In reply please quote: SSD-10436

REQUEST FOR ADVICE ON ENVIRONMENTAL IMPACT STATEMENT – 6 JOHNSTON CRESCENT, HORSLEY PARK – ESR HORSLEY LOGISTICS PARK (SSD-10436)

Council officers have reviewed the Environmental Impact Statement (EIS) prepared by Urbis dated July 2020 and the supporting technical reports, and request that additional information and clarification be provided by the applicant for Council to be able to fully assess the potential impacts of the proposed SSD. These issues are detailed further in this submission.

1 Site Facilities Plan (Lot 201)
MS-A010 1:500 @B1

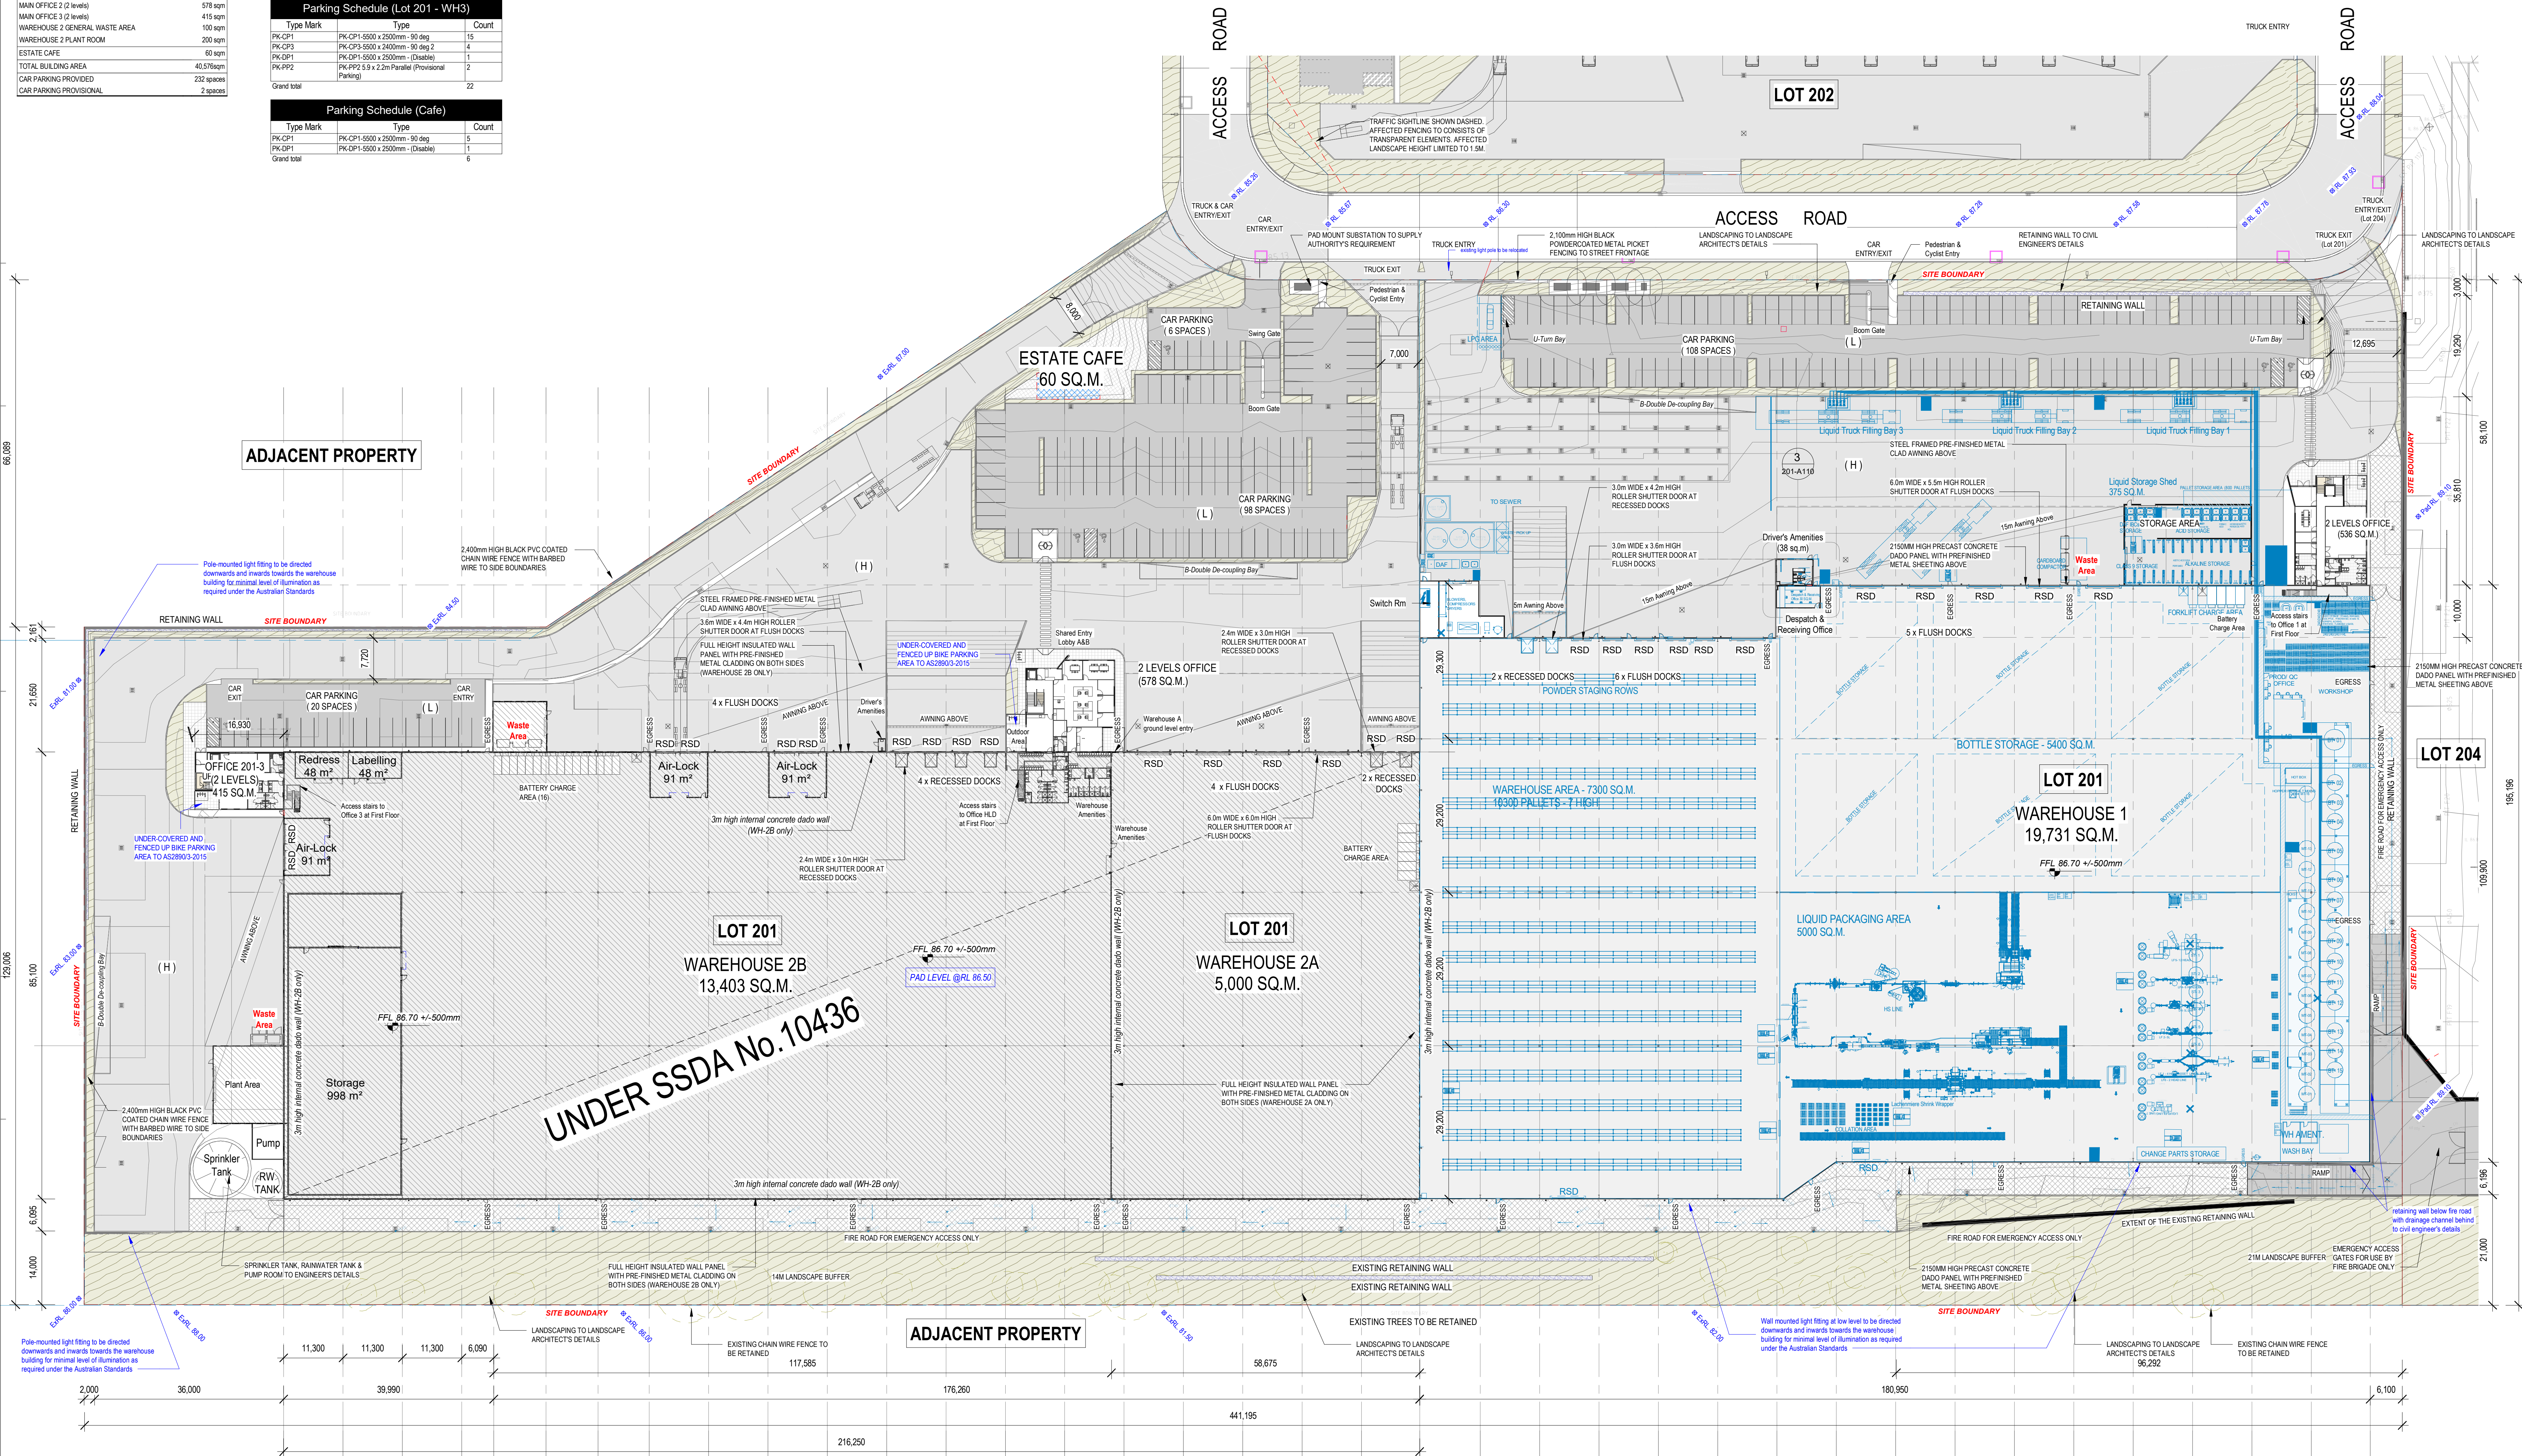
The Waste Management Plan prepared by SLR dated May 2020 is considered satisfactory. A review of the Final Architectural Plans illustrate waste storage for only Lot 201 and not on the other lots part of the Stage 2 development. Waste storage shall be

provided and indicated on the architectural plans for each lot, in addition waste storage areas should also be less than 30 metres away from the office area to avoid the potential for unlawful dumping.
